REQUEST

Current Zoning: NS (neighborhood services)
Proposed Zoning: N2-A(CD) (neighborhood 2-A, conditional)

Approximately 12.3 acres located along the north side of Rocky River Road and the east side of John Russell Road.

The petition proposes a residential community of up to 115 multi-family attached townhome style units and up to 9,000 square feet of non-residential uses.

Rezoning Site Plan

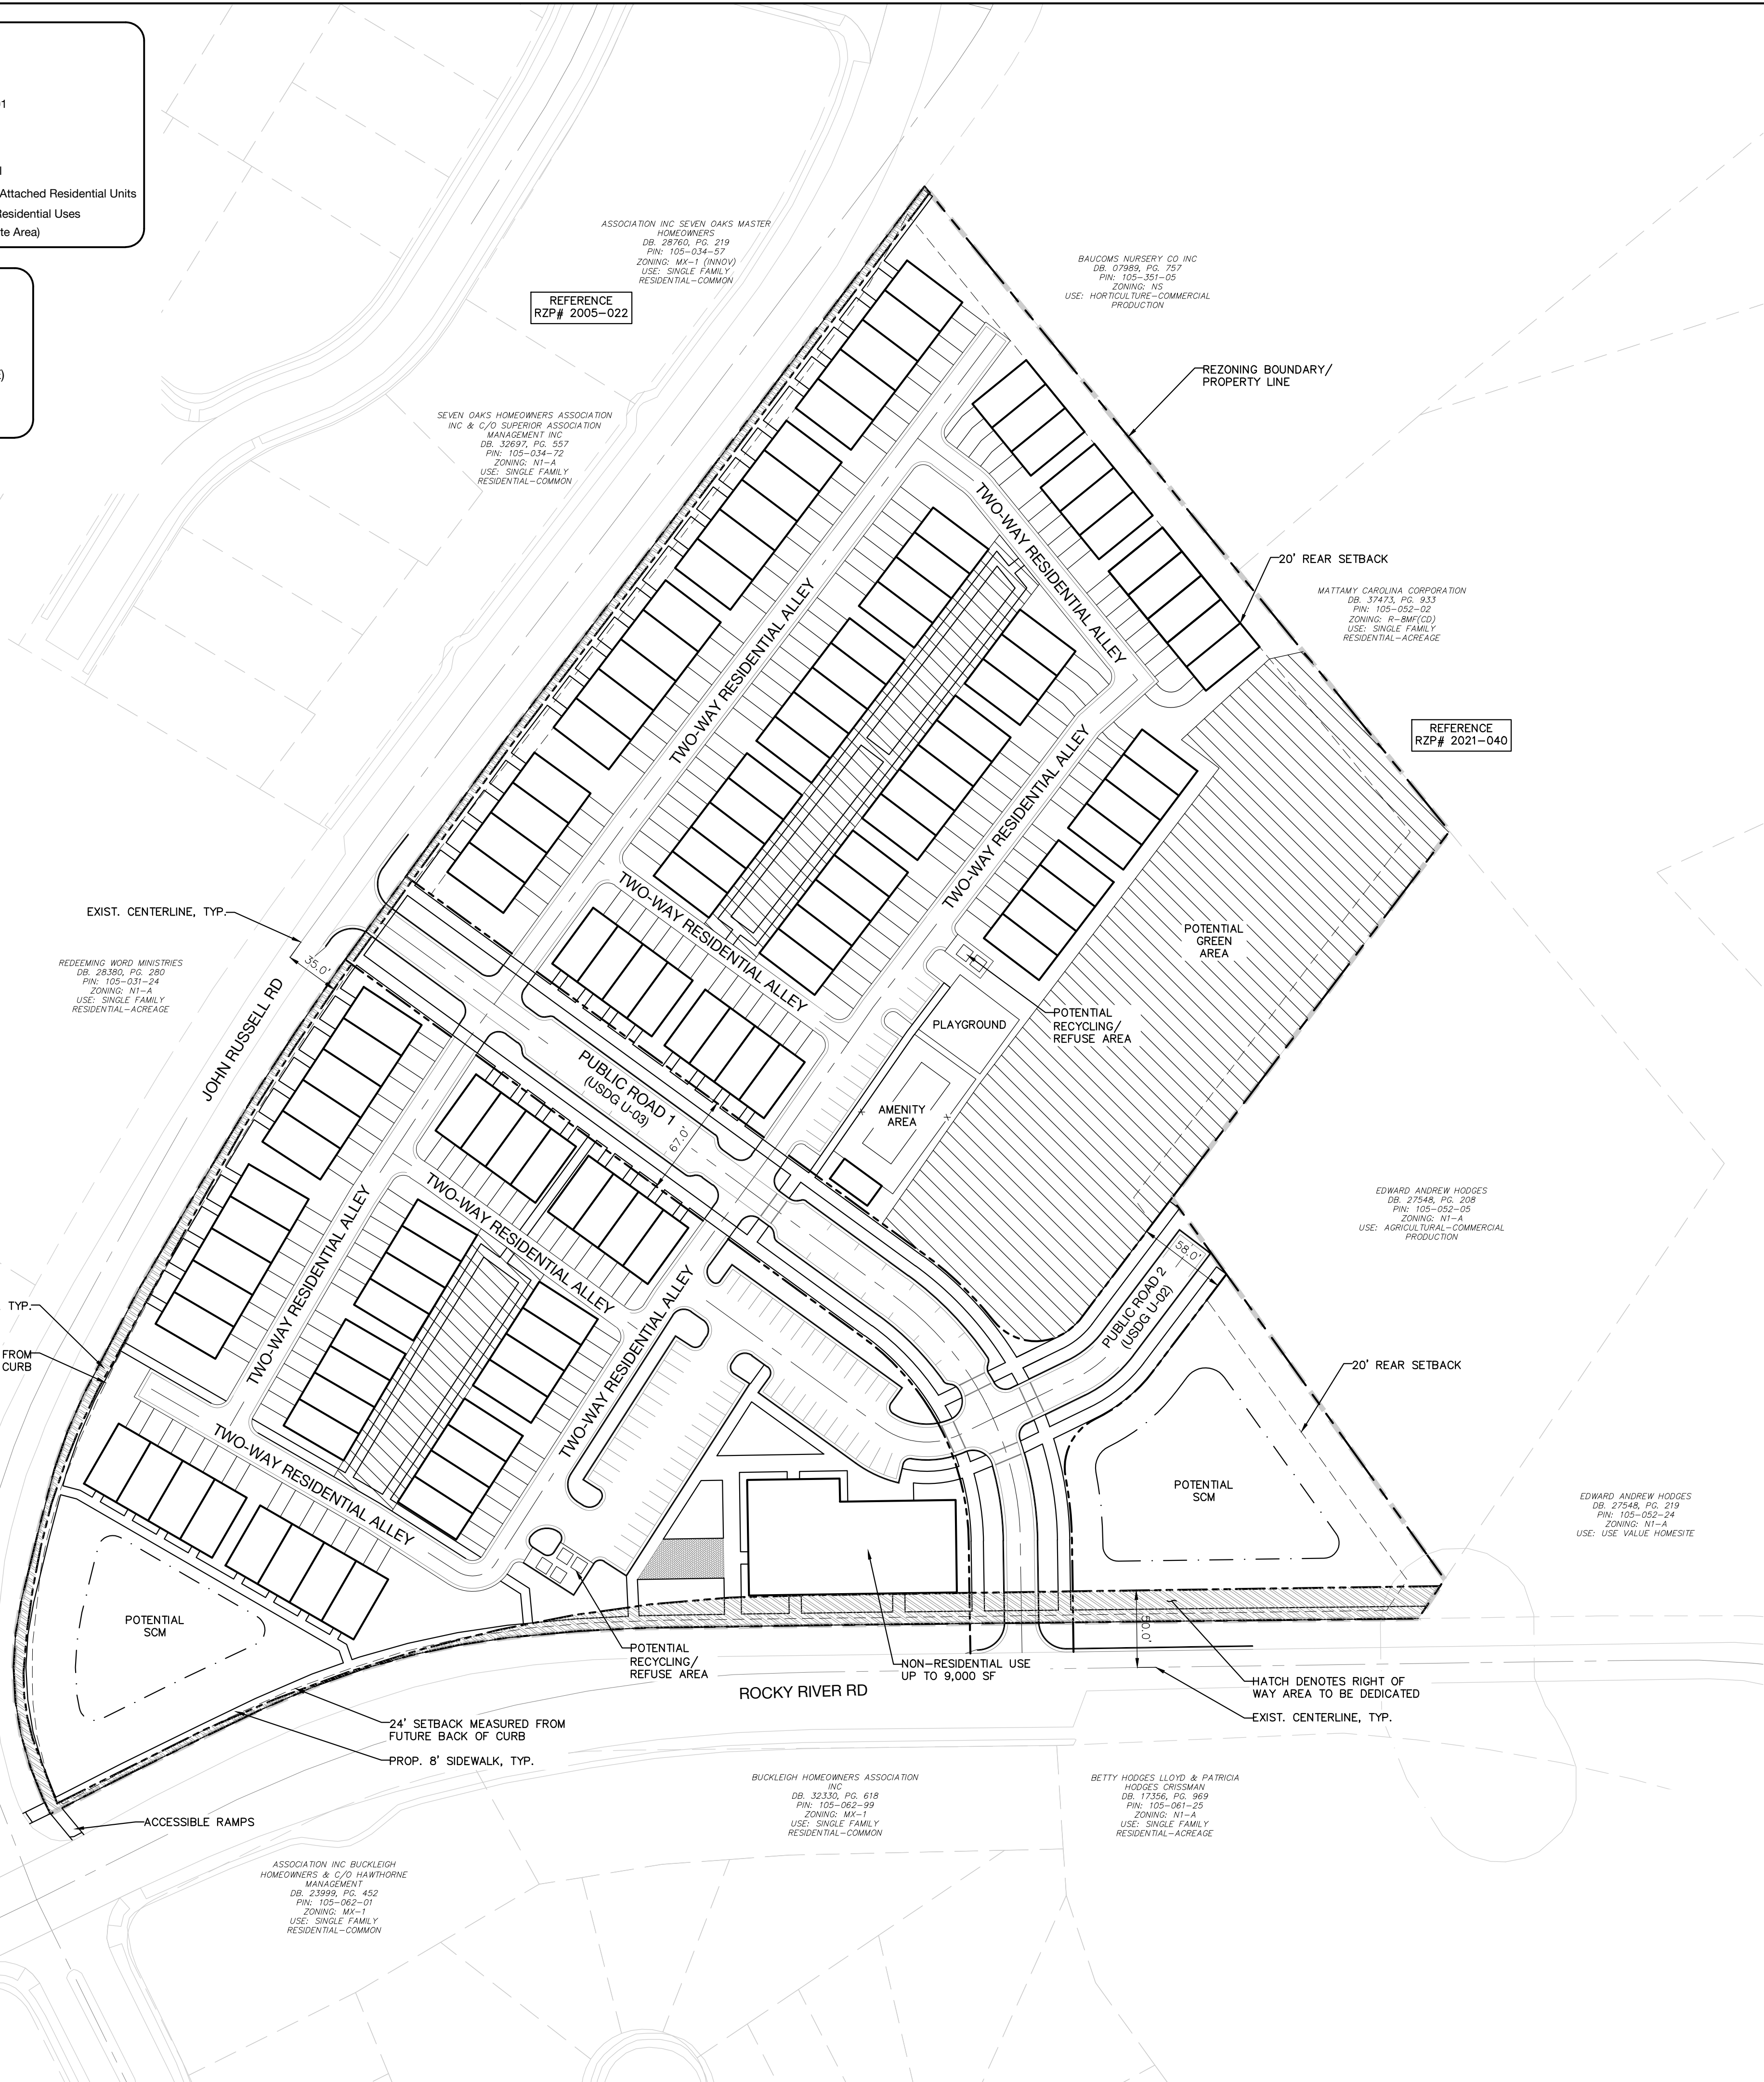
1. Provide a heritage tree survey.
2. No structure (dumpster) shall be allowed within 10-feet of the tree save area.
